Our Ref : S076158.015

File No : MP10\_0104

**RE West Circular Quay Public Domain Upgrade Works, Circular Quay /  
The Rocks (MP10\_0104)**

The City has reviewed the Environmental Assessment and notes the conceptual nature of the proposal. The City generally supports the design concept but cannot give its full support to the proposal in its current form due to the lack of design resolution and detail relating to some key aspects of the proposal.

7. Lighting

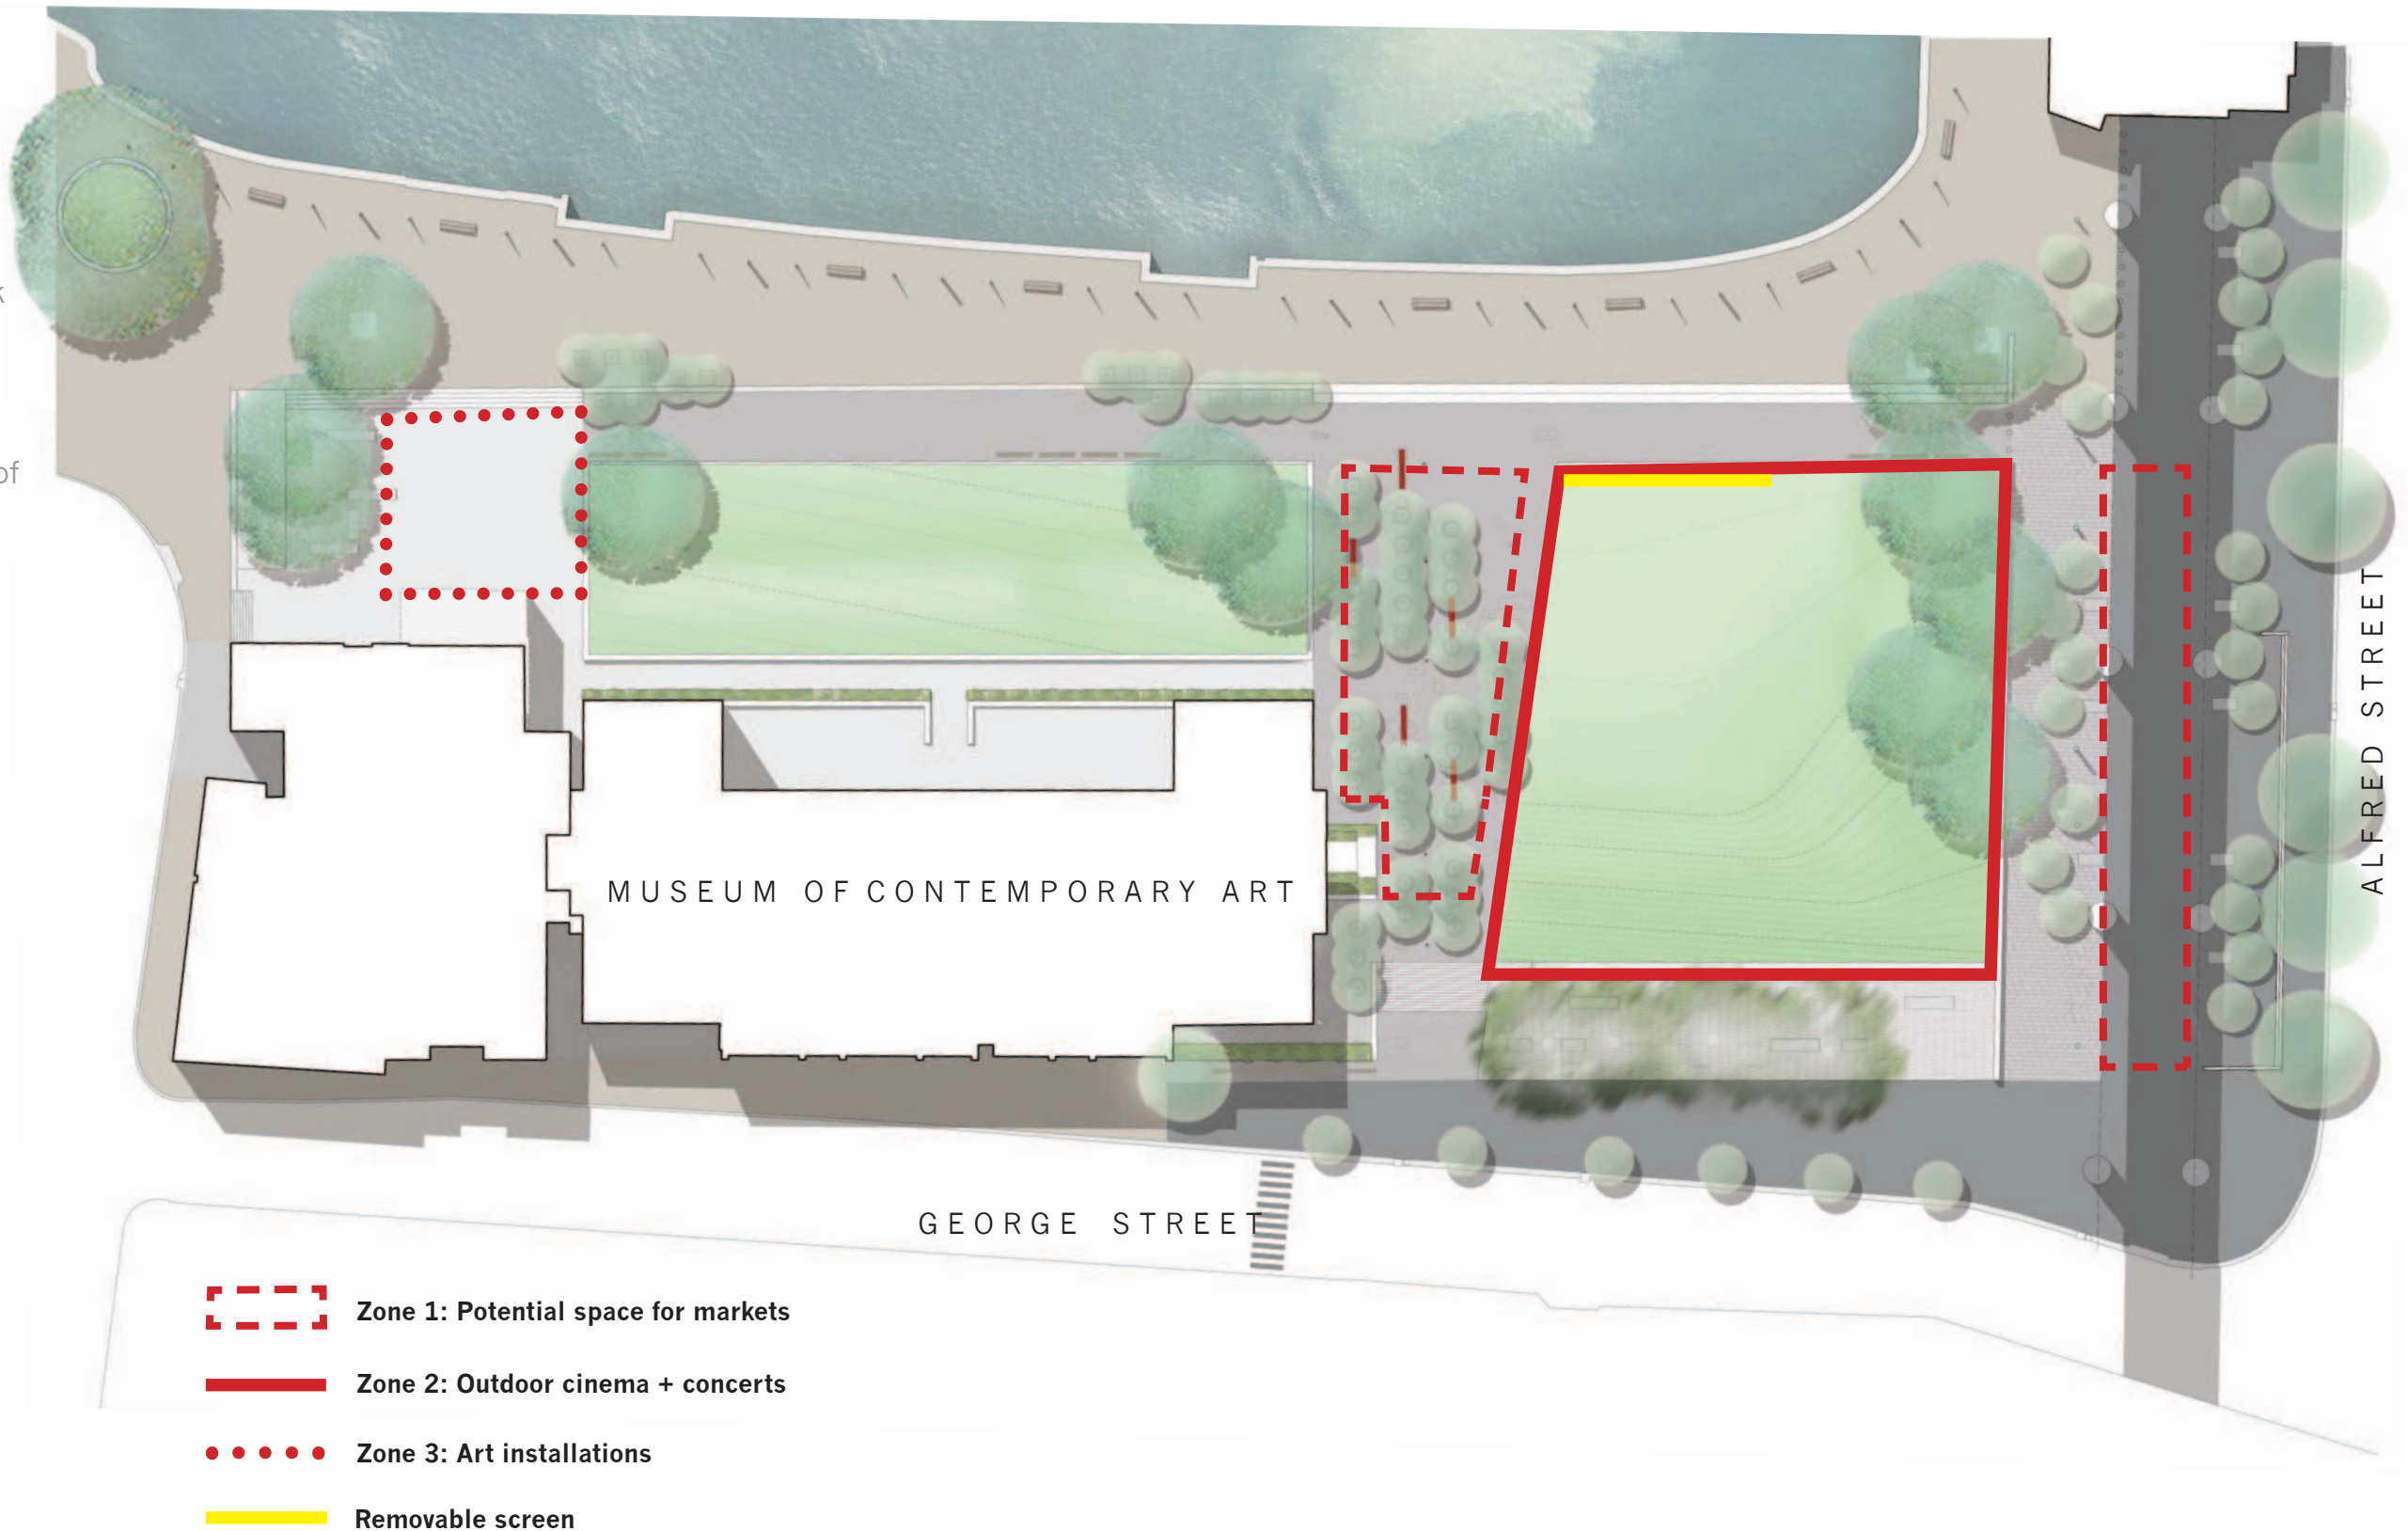
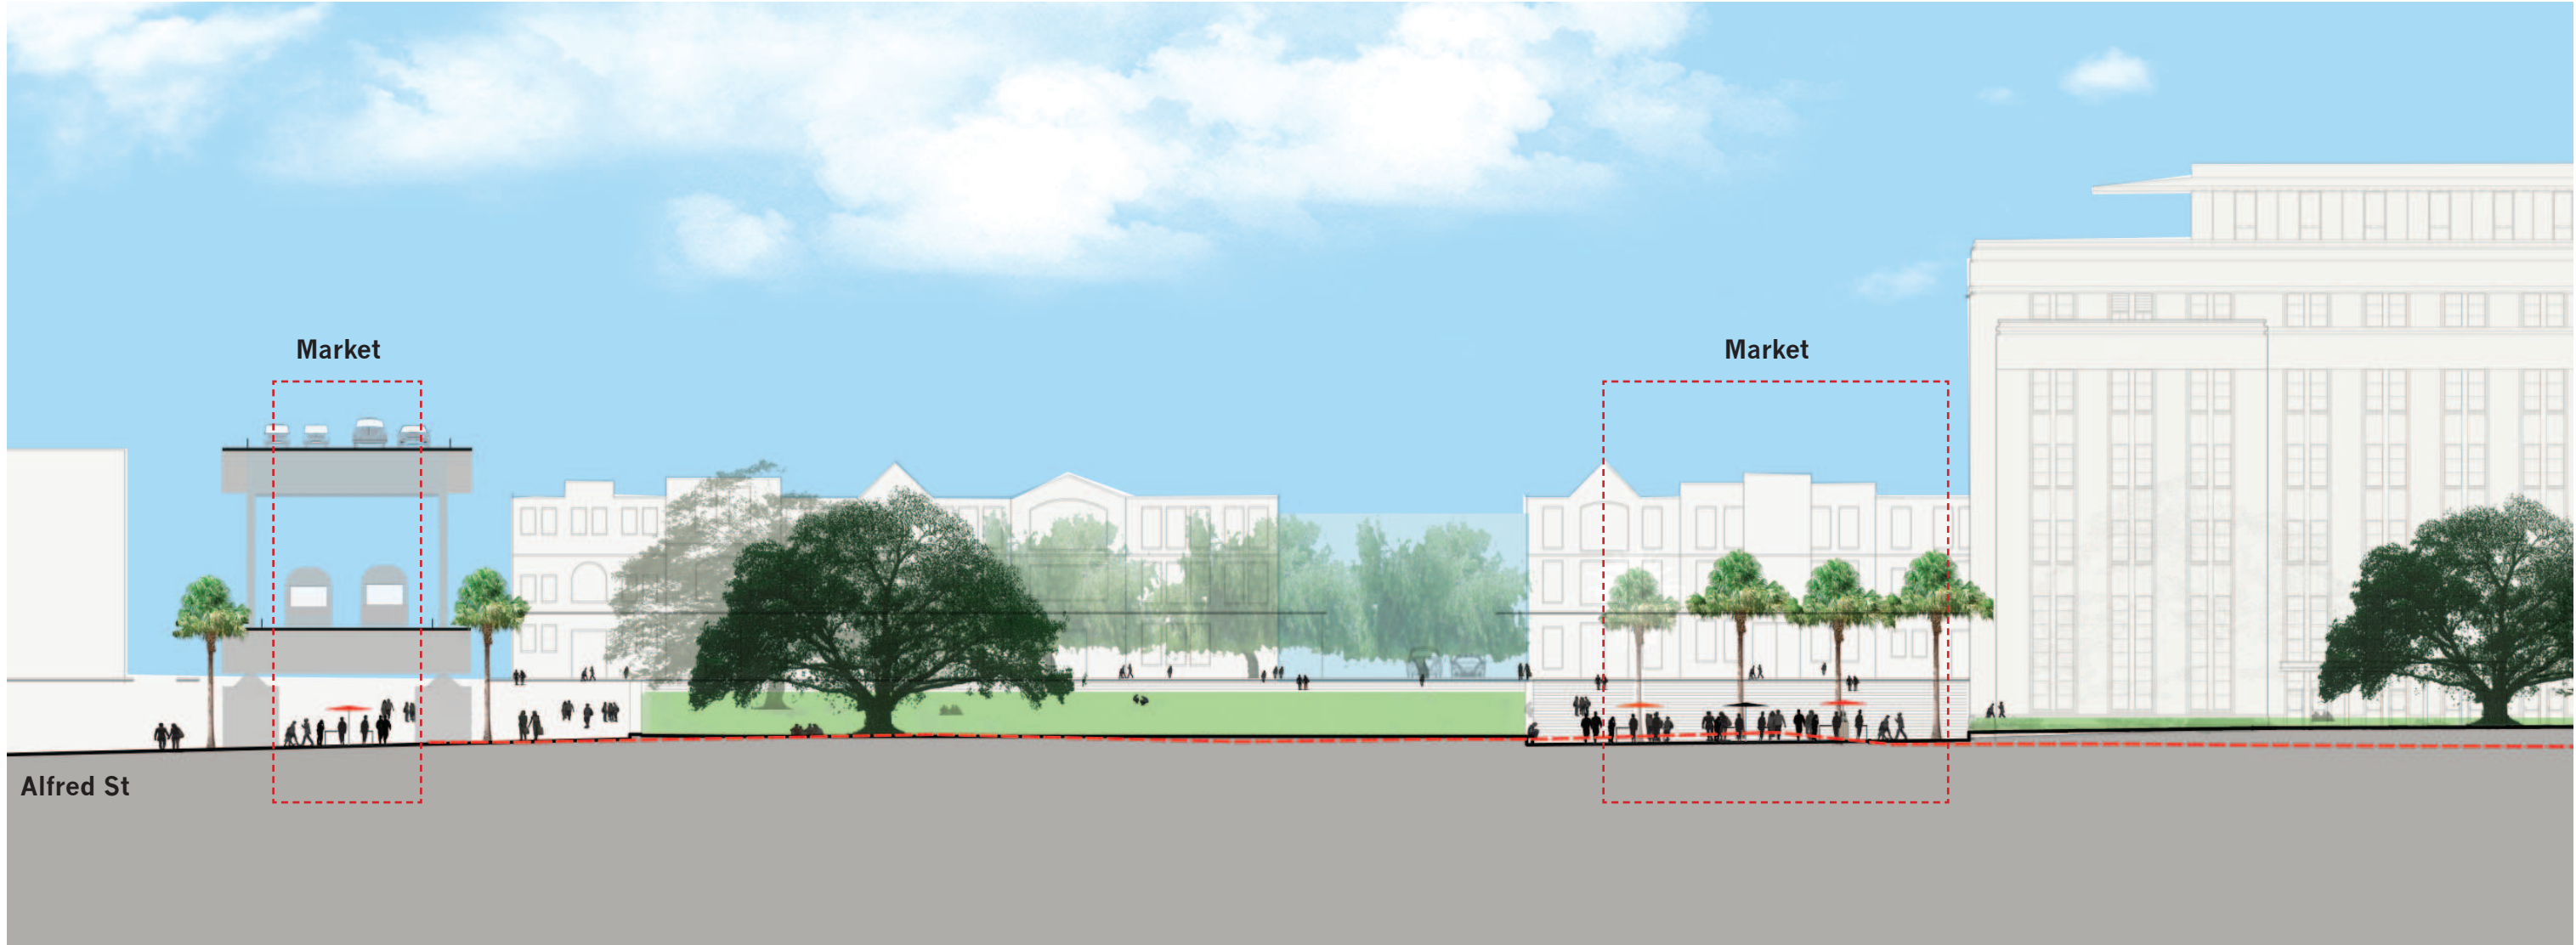
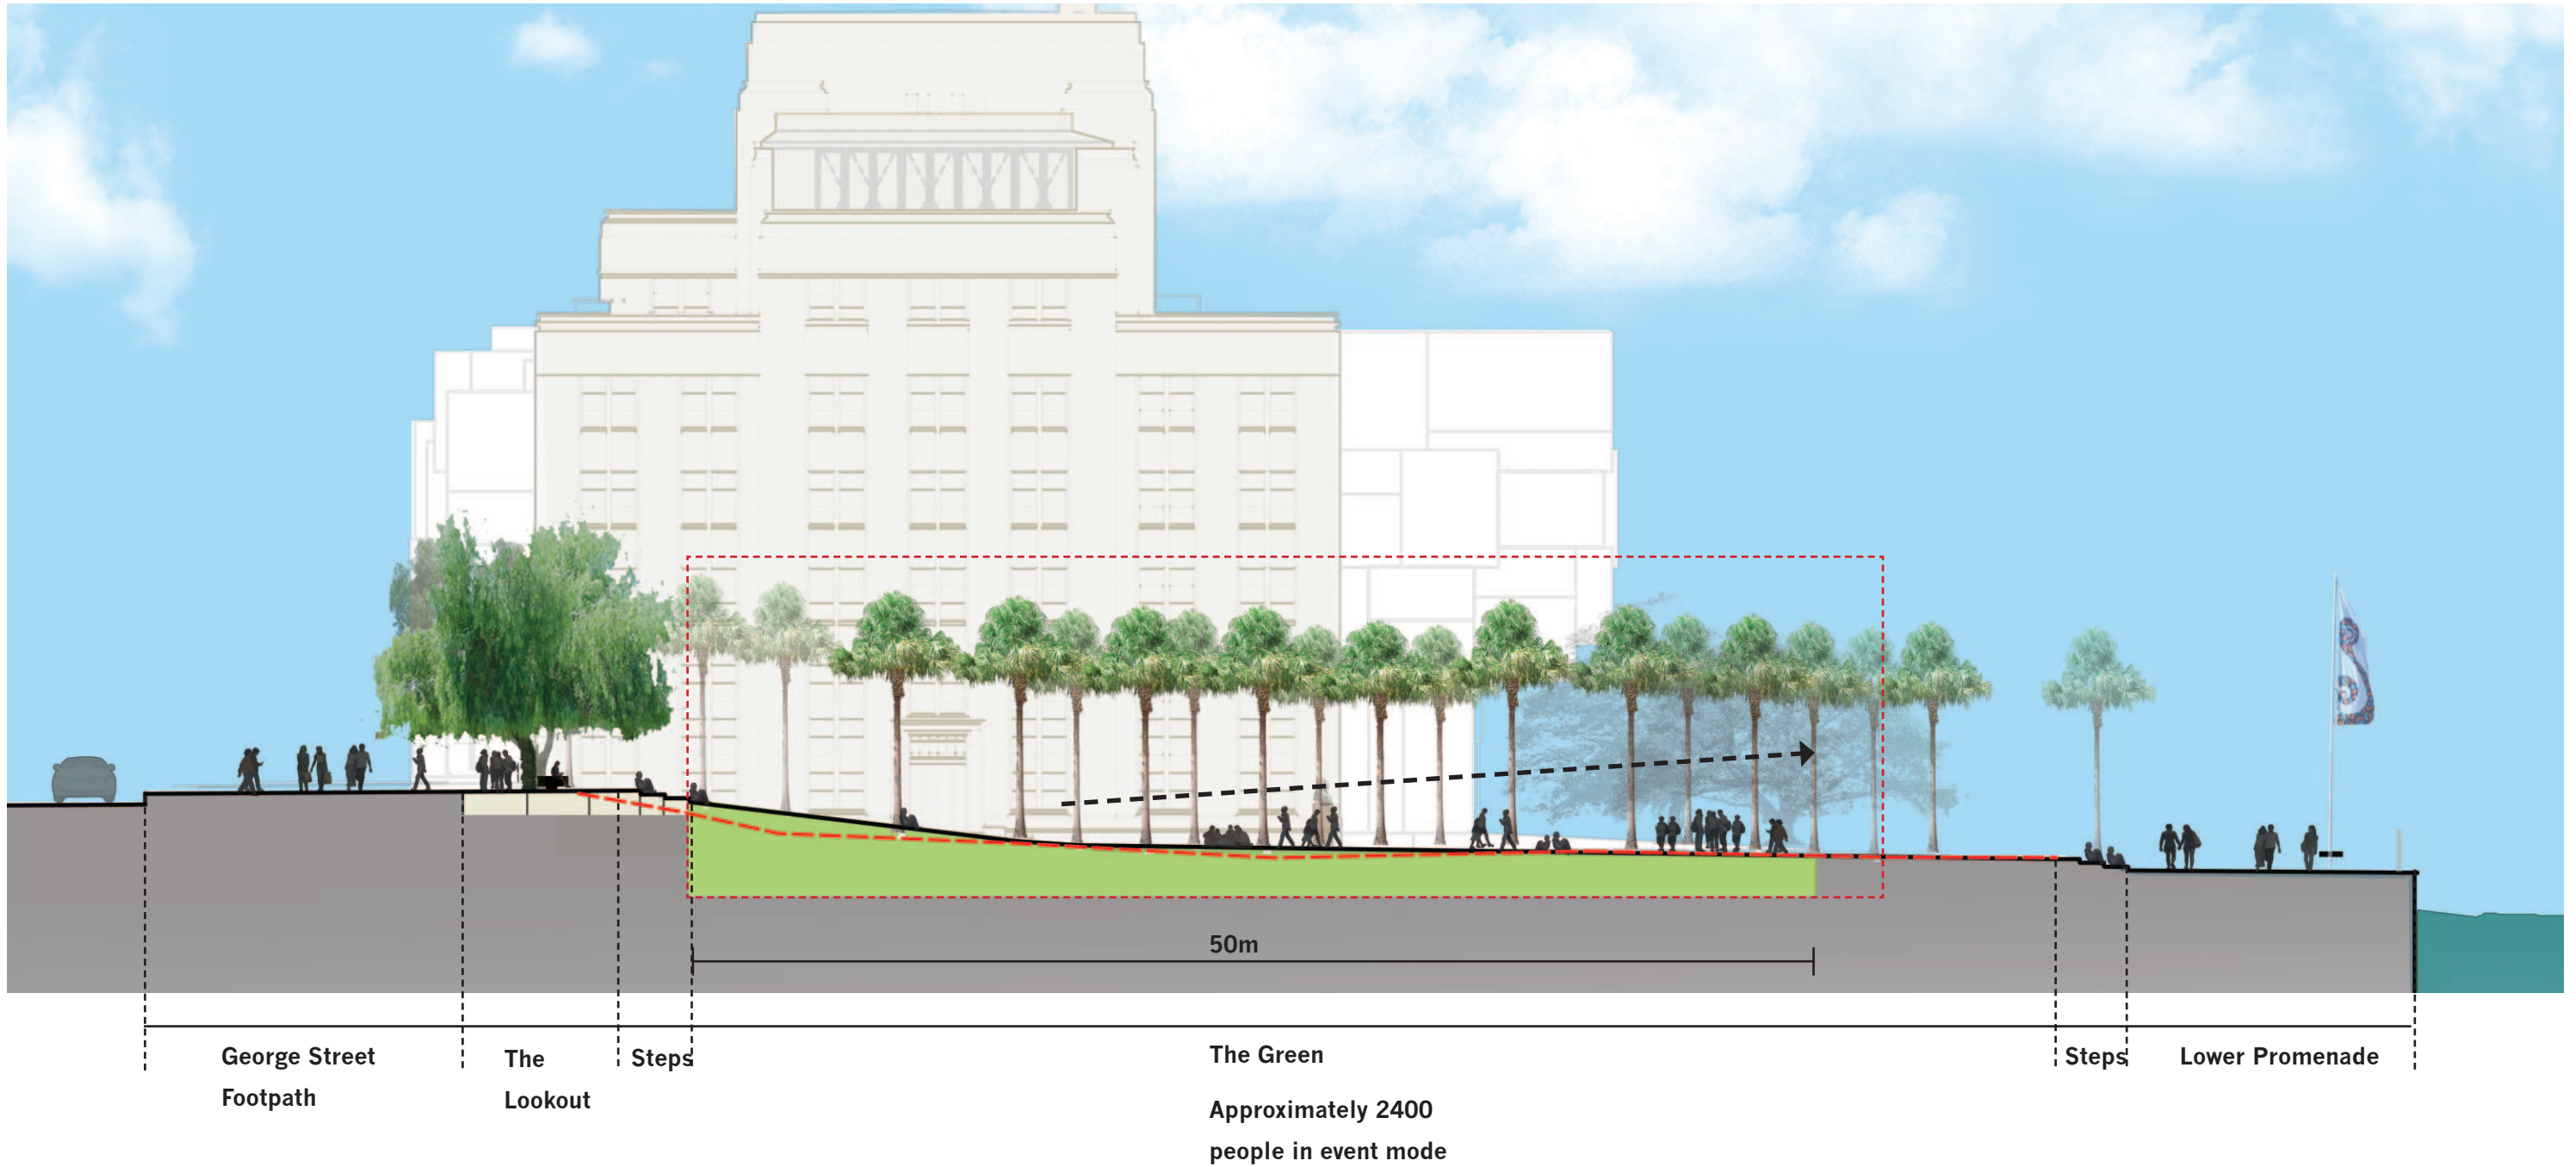
- a. The “sphere” type pole-mounted lighting design was not supported by Jørn Utzon for use around the Opera House and should not be continued.
- b. The cost of the entire lighting scheme is potentially grossly underestimated and/or inadequate and should be re-evaluated.
- c. Insufficient details are provided about the type of light fitting in “Market Wharf”.
